**re:      Geotechnical Recommendations - Concrete Trenches**  
          **Proposed Residential Development**  
          **2710 Draper Avenue - Ottawa**

**date:    August 19, 2019**

**file:    PG1630-MEMO.27 Rev.01**

CROSS SECTION A-A

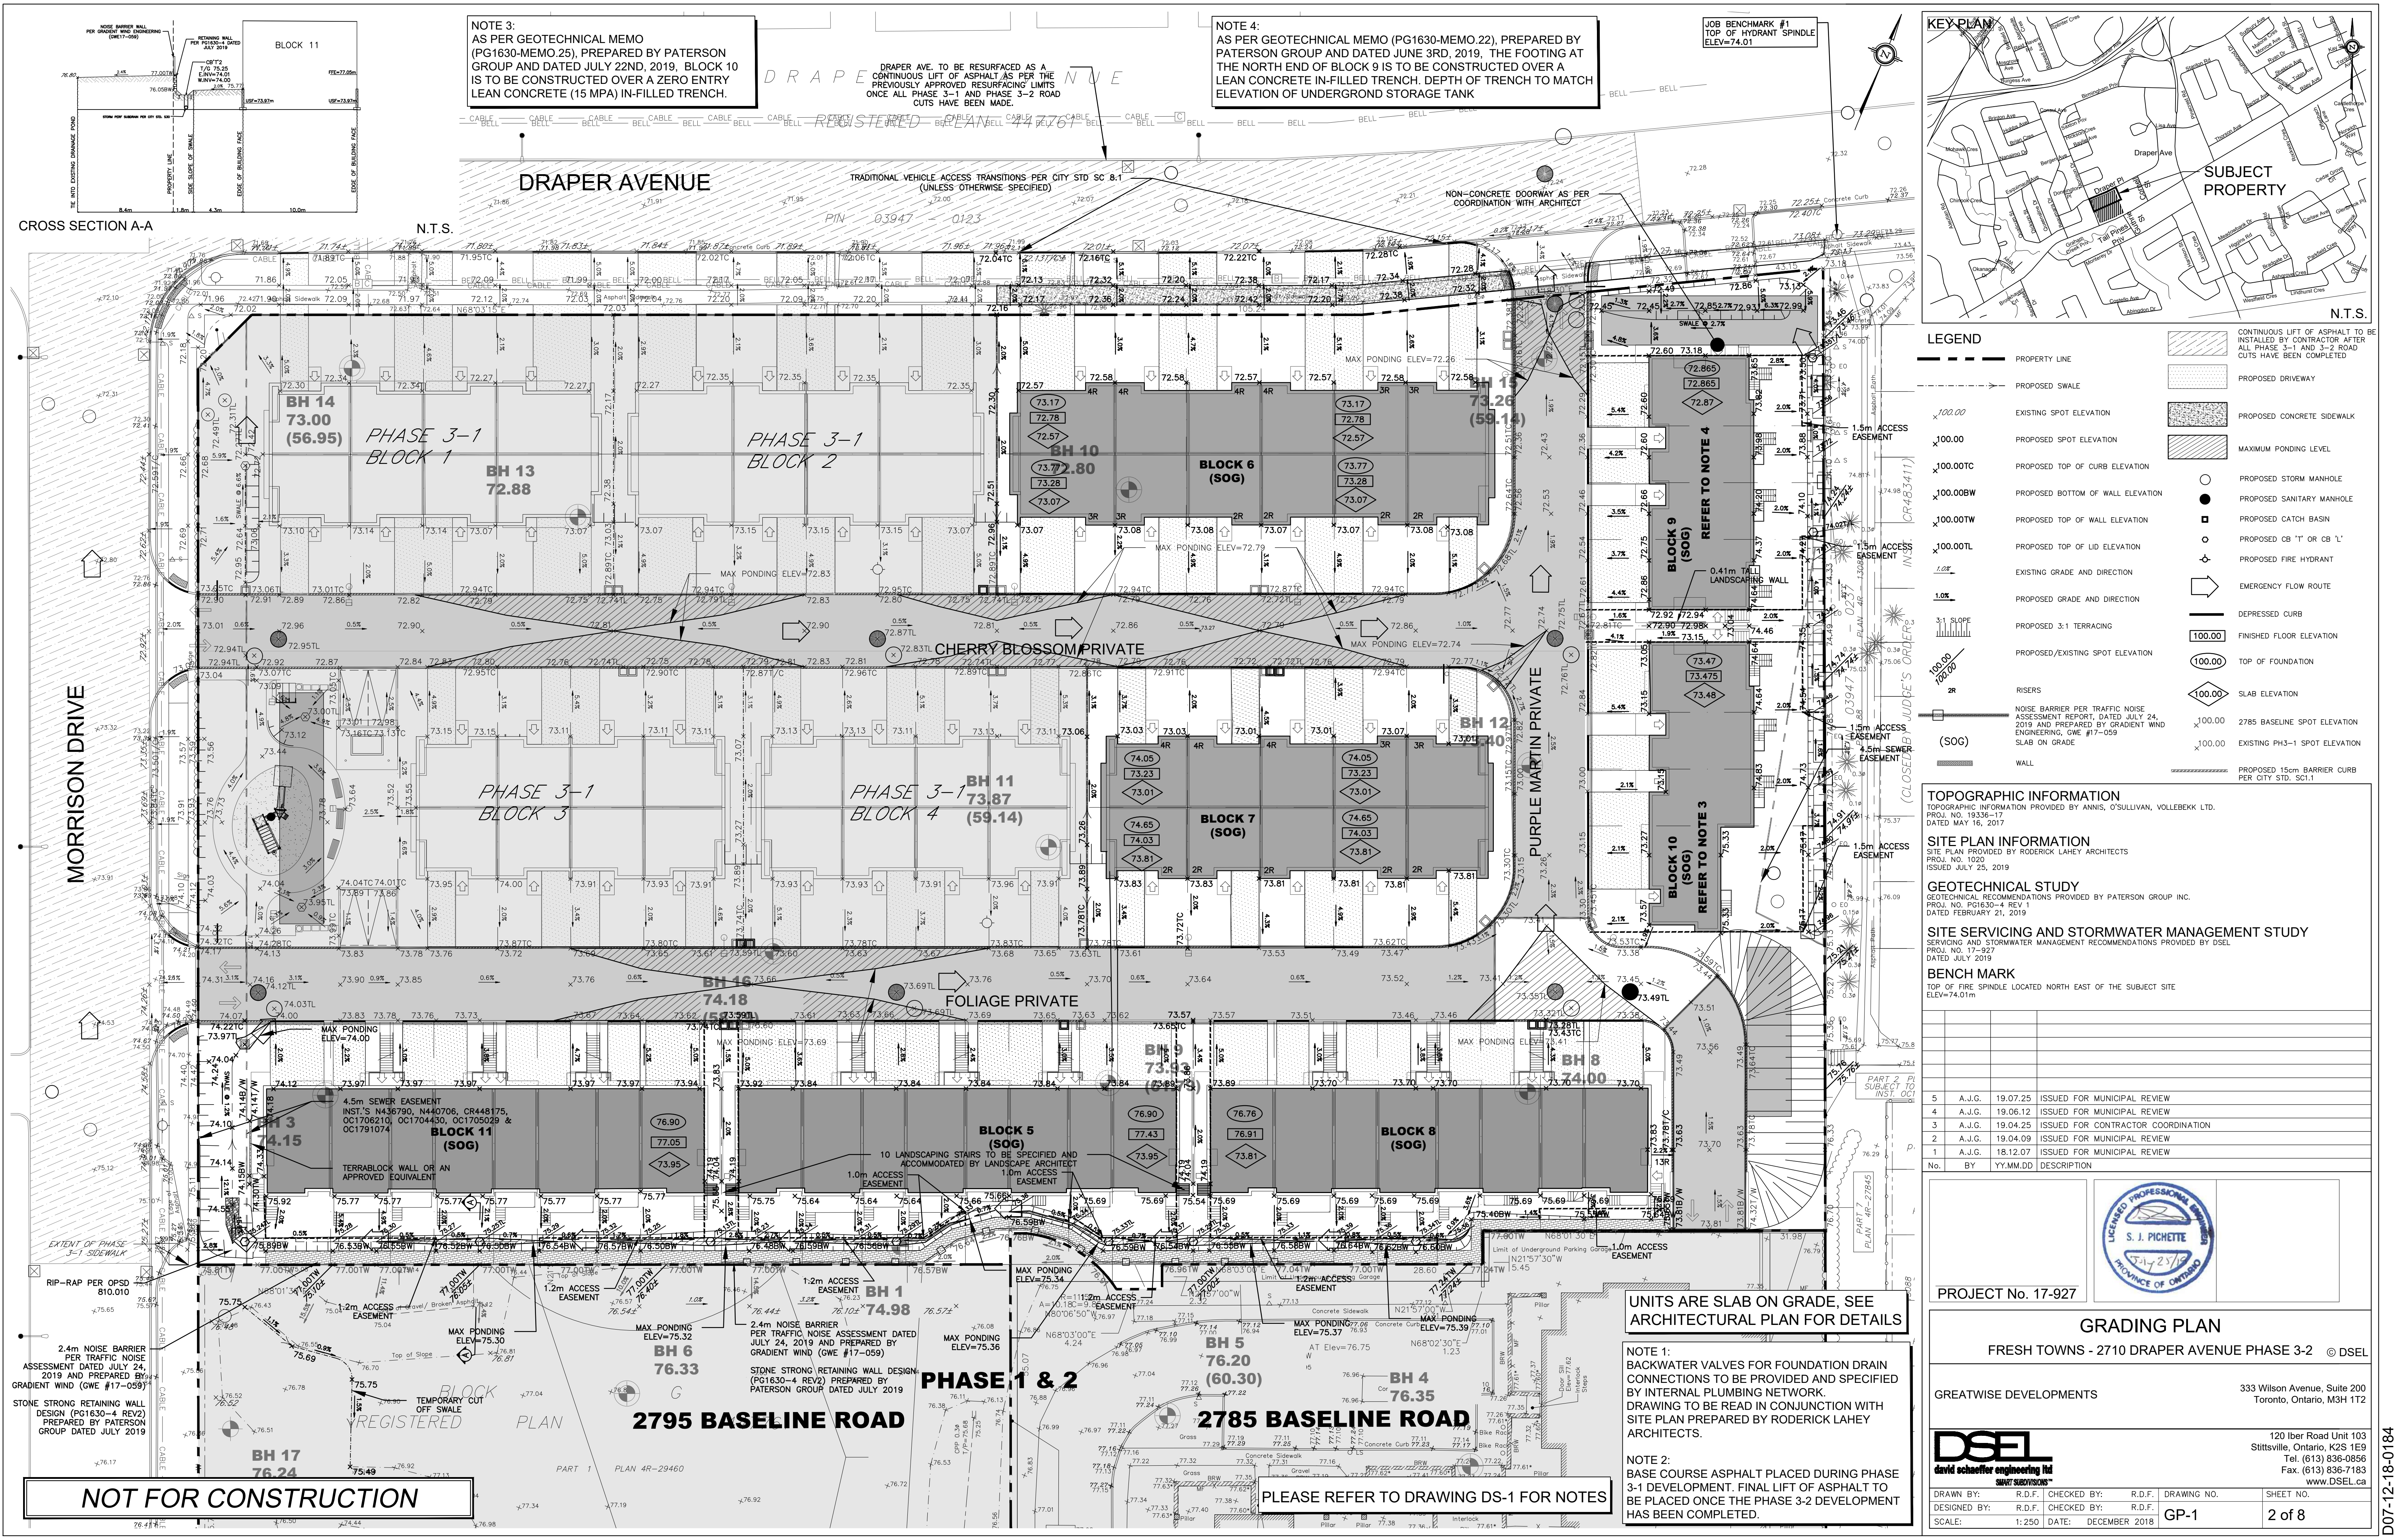
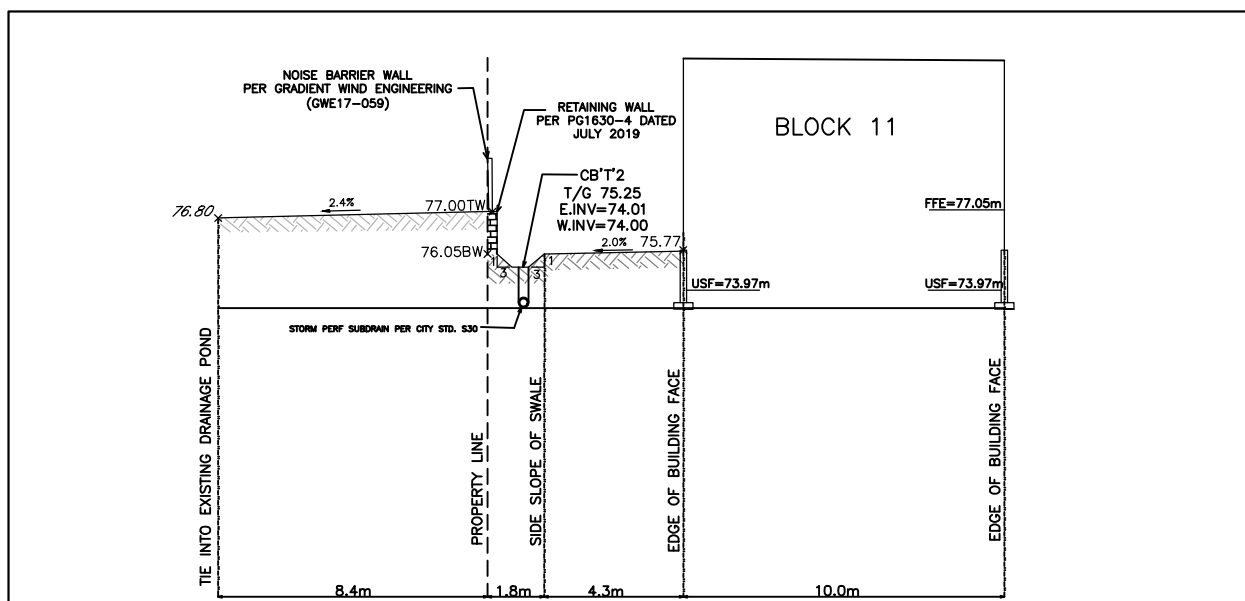
After the above noted recommendations were provided, concerns were raised regarding providing concrete in-filled trenches below the sidewalk adjacent to the storage tank and the landscaped steps adjacent to the north side of the building. Paterson has reviewed the concerns noted by the City of Ottawa and has provided the following recommendations.

The adjacent landscaped steps and sidewalk are not required to be provided with a concrete infilled trench. The requirement for the concrete infilled trench is for the building footings only, as described above.

If excavation down to the storage tank is required in the future, the sidewalk could be removed and reinstated, or provided with temporary shoring. The landscaping steps will not be affected by future excavation of the tank as they are very light structures. If damage were to occur to the steps, minor repairs/reinstatement could be made as required.
